From: Nick Howard
Sent: 09 May 2017 16:06
To: Planning.Responses
Subject: Re- Planning Application - BR/98/17/PL - Butlins

Food Safety Comments:

B	Kitchen ductwork amended for coment	23.03.17.
A	Discharge duct height reduced	23.03.17.

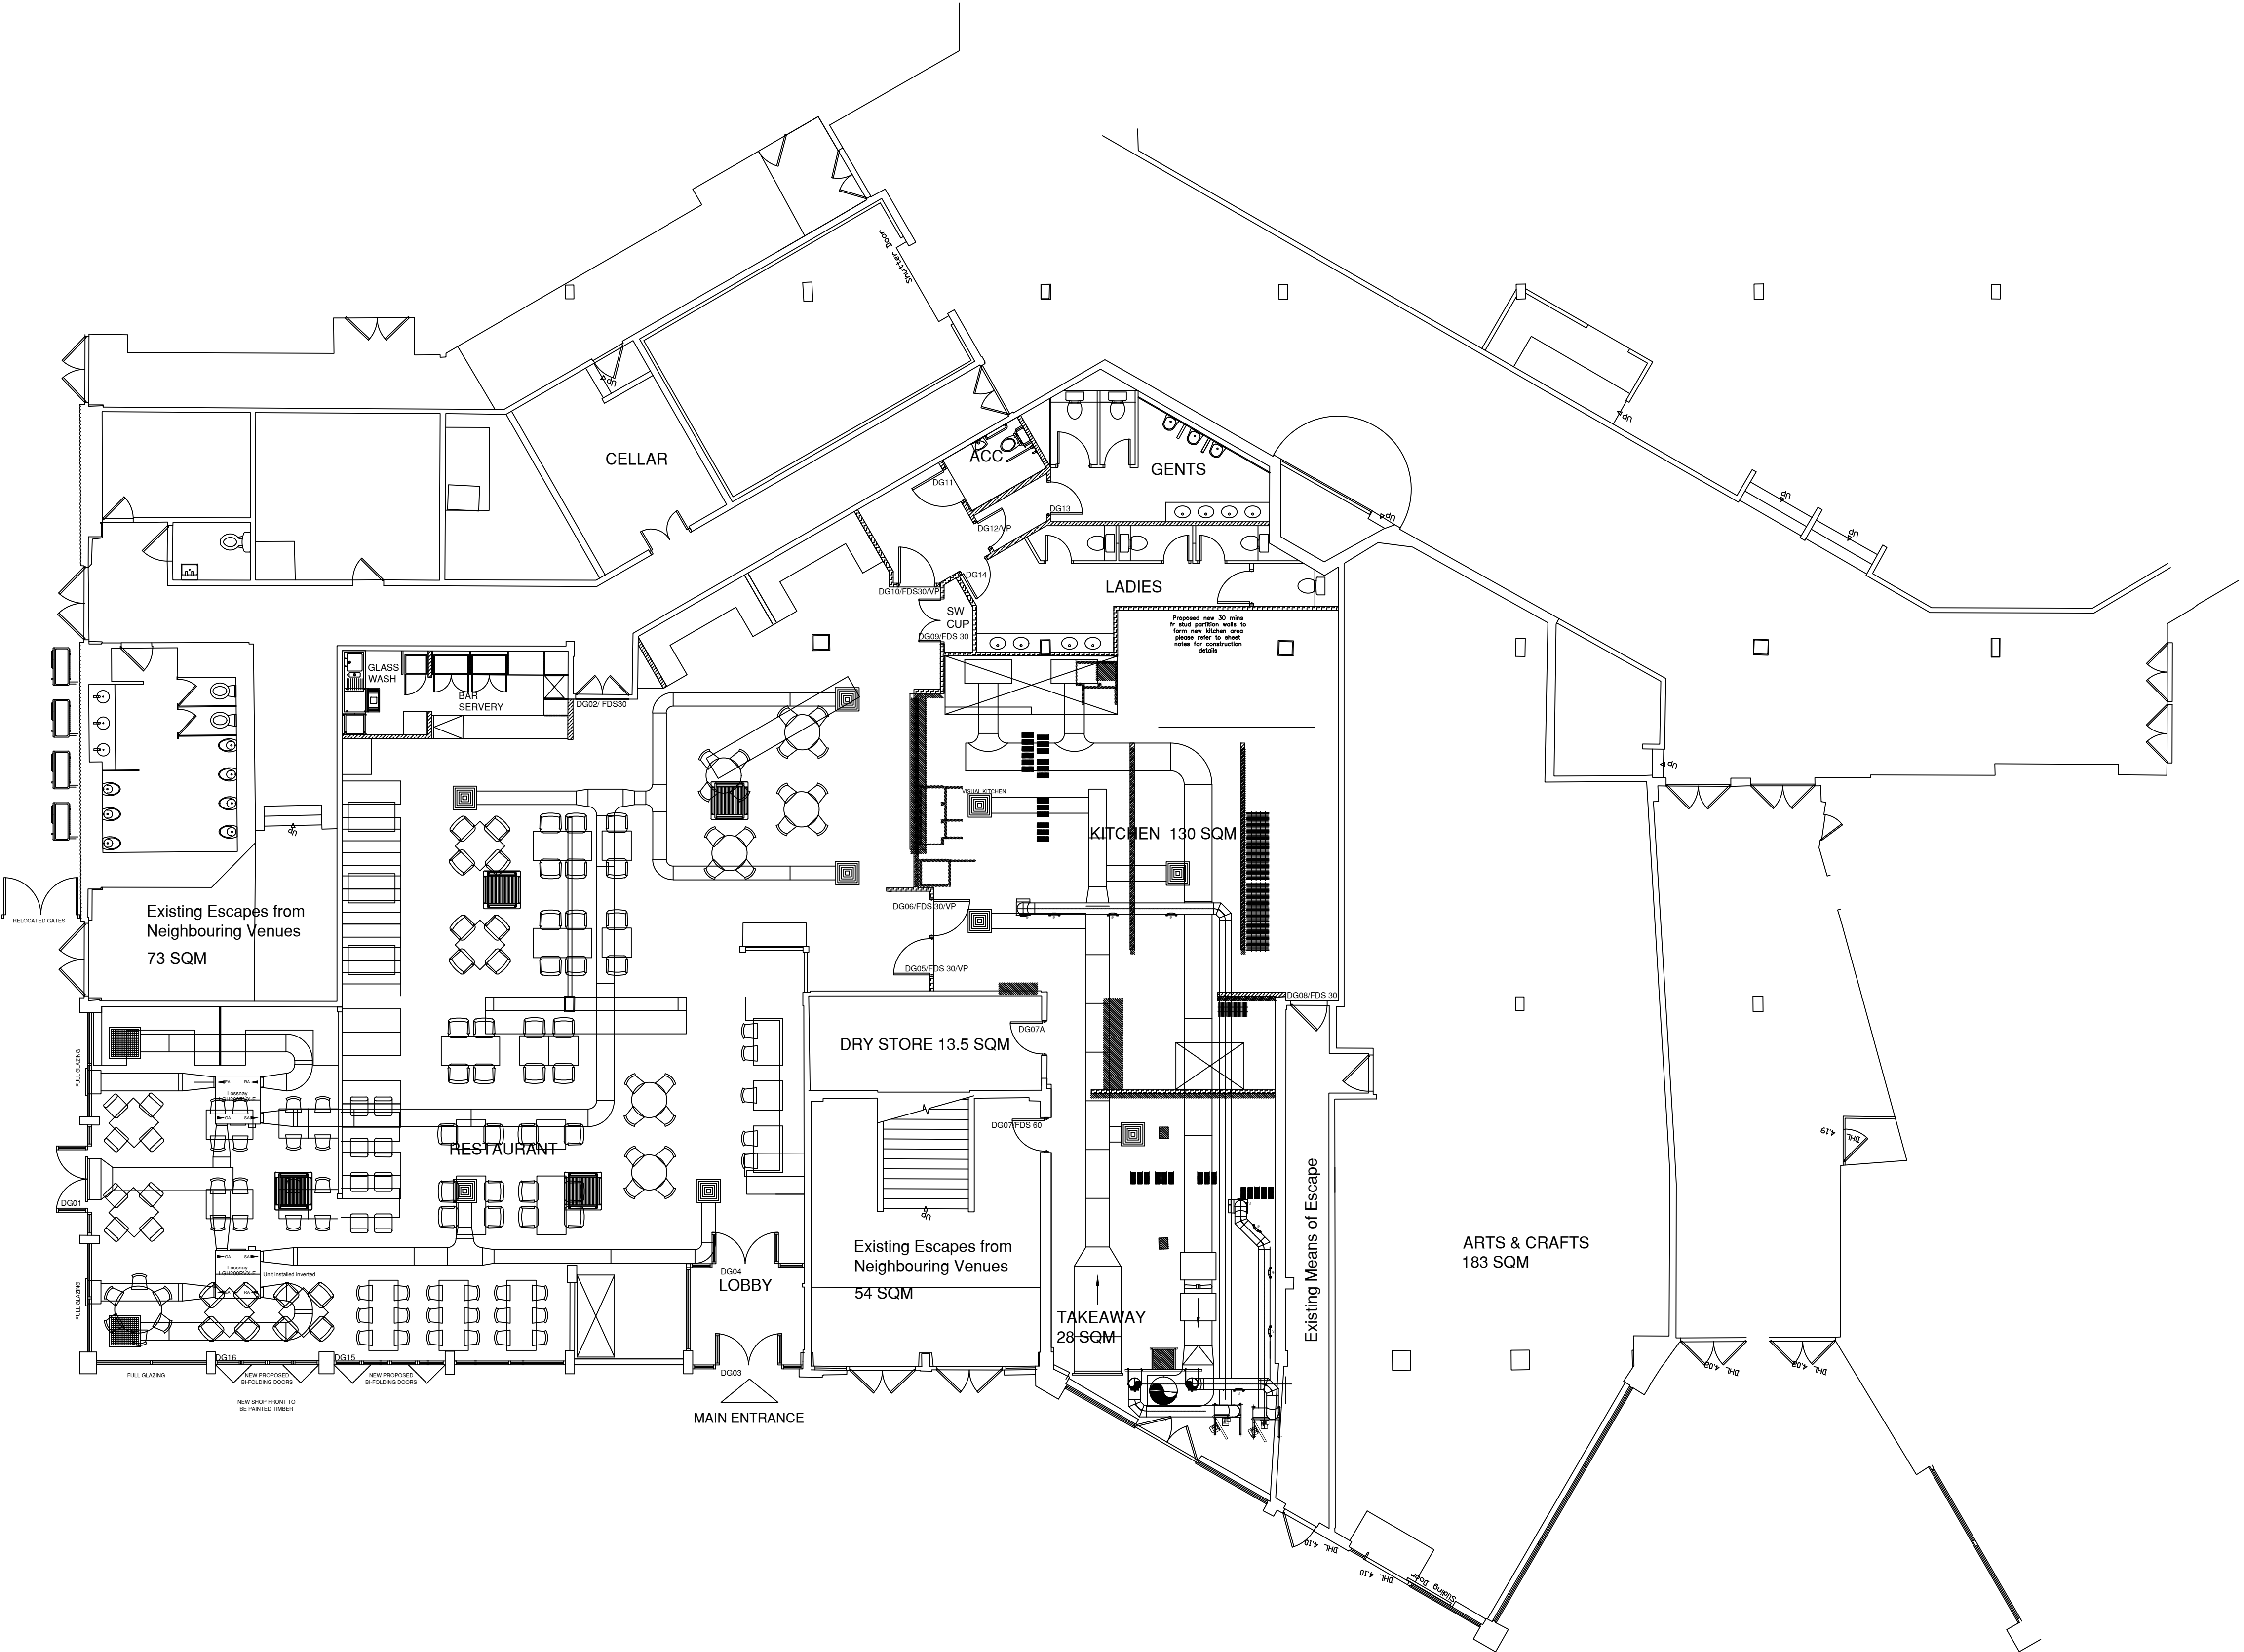
- ii. Can you confirm which toilets the staff will use
- iii. I noted the proposed external extract for the kitchen ventilation system is on a flat roof. It would be advised for the dispersion from the external extract to the system be at a higher level e.g. second storey roof height for more effective dispersion of odour/gases etc.
